## Application for a Non-Material Amendment Following a Grant of Planning Permission

Land to the North of Cold Overton Road

2021/1334/RES

PROJECT : **2108 : LAND NORTH OF COLD OVERTON ROAD, LANGHAM**  
DWG NO : **2108 - 15 - PROPOSED PLANS & ELEVATIONS : PLOT 16**  
REVISION : /  
SCALE : **1 : 100 @A1** DRAWN BY : **SW**

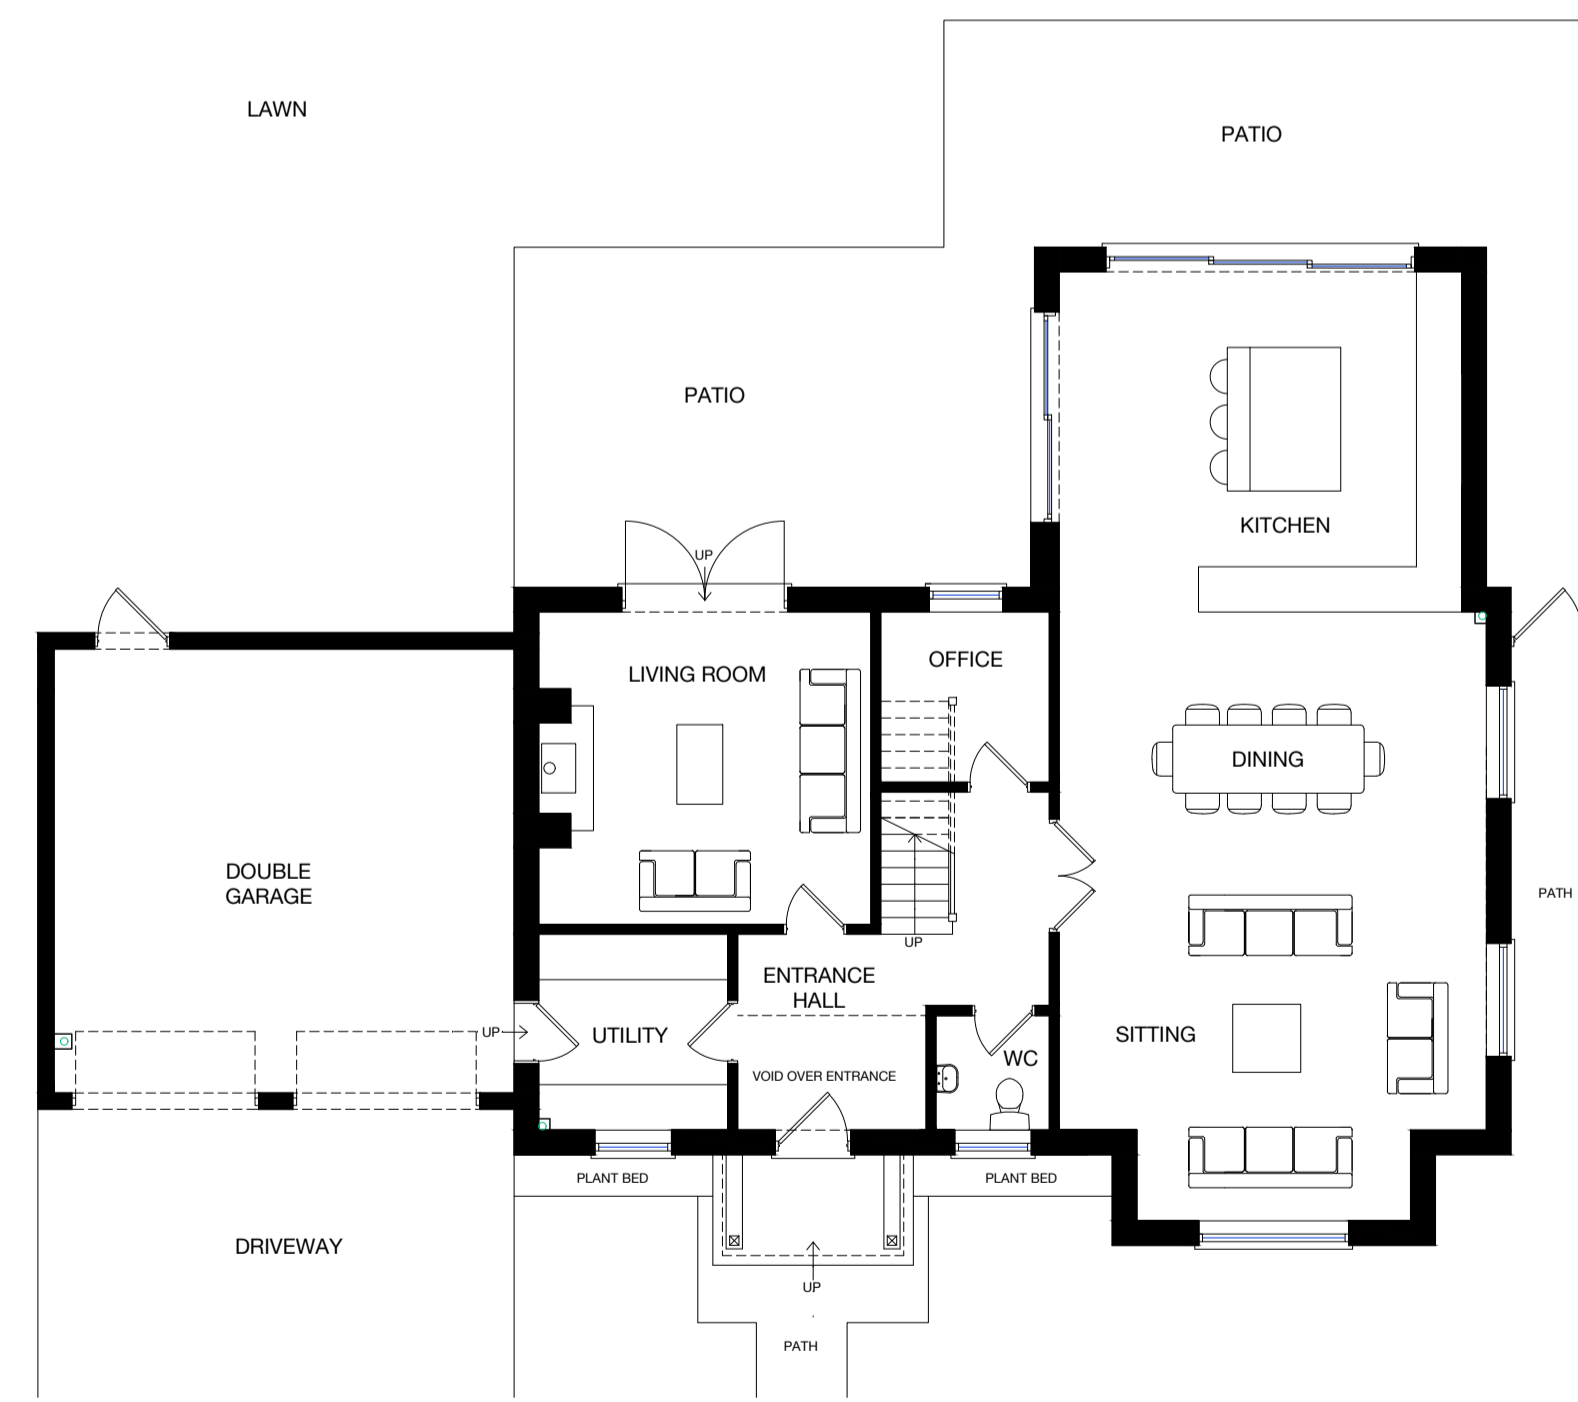
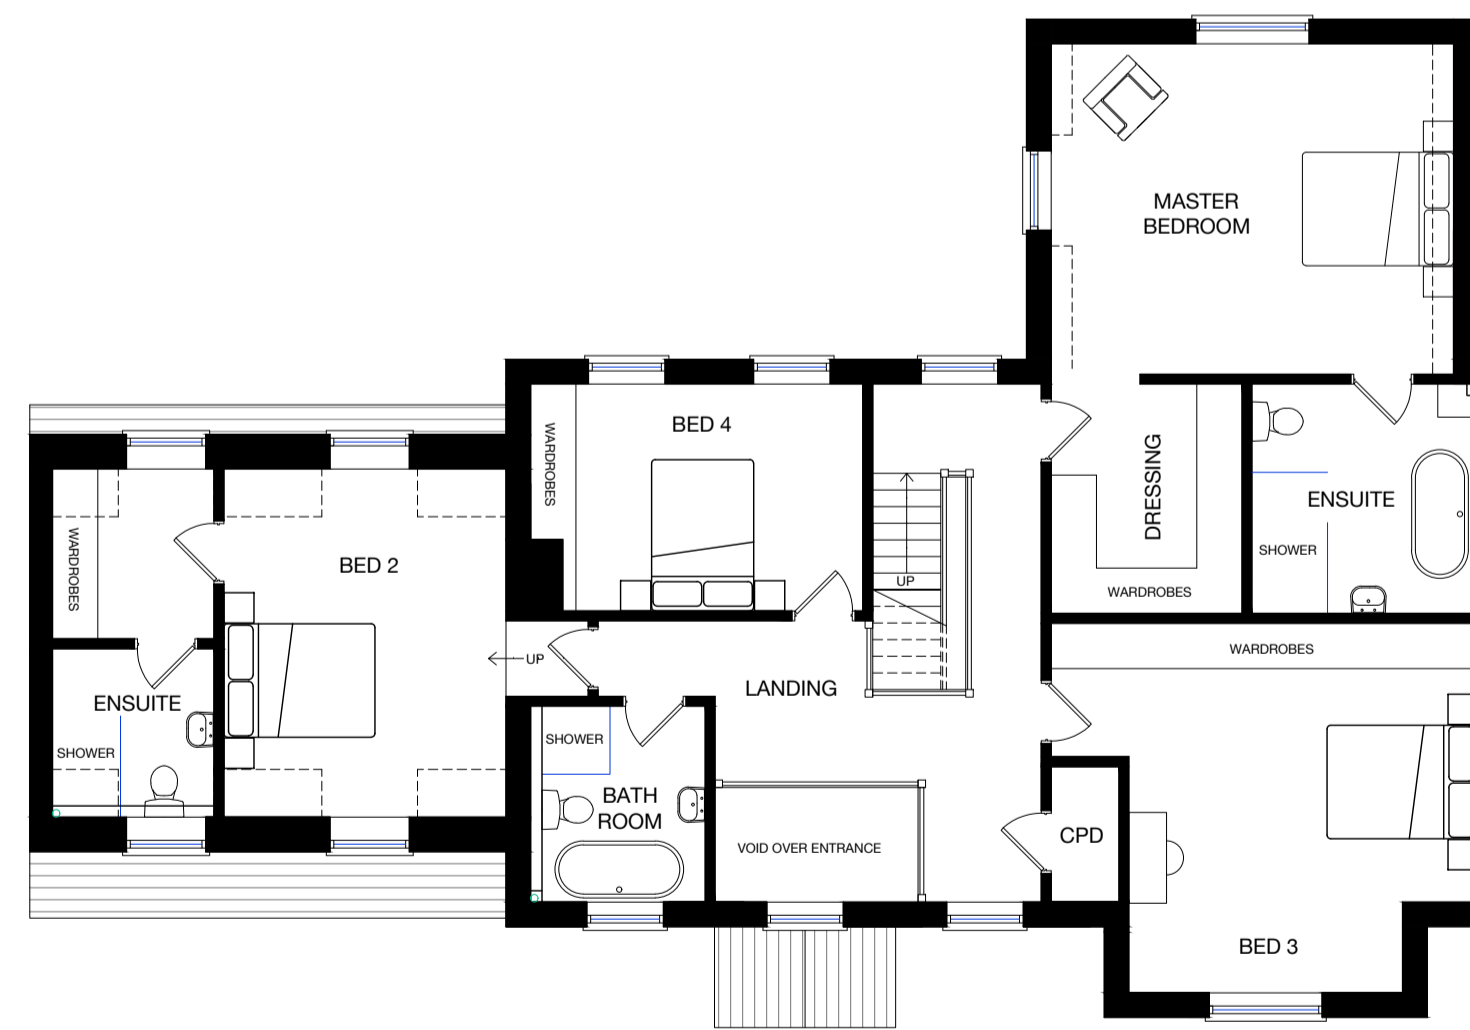
Amendments to the site layout to improve turning areas and minor alteration in the layout of plots 16 and 17, thus affecting the garden of plot 10.  
Minor alterations to the appearance of Plot 16 and 17 in response to the changes to the site layout.  
Landscaping plan updated to reflect changes to the improved site layout.

2108 - 1000h - Proposed Site Plan with Levels  
2108 - 05c - Proposed Plans and Elevations Plot 4  
2108 - 14a - Proposed Plans and Elevations Plot 17  
2108 - 15 - Proposed Plans and Elevations Plot 16  
GL1119 01F Detailed Landscape Proposals
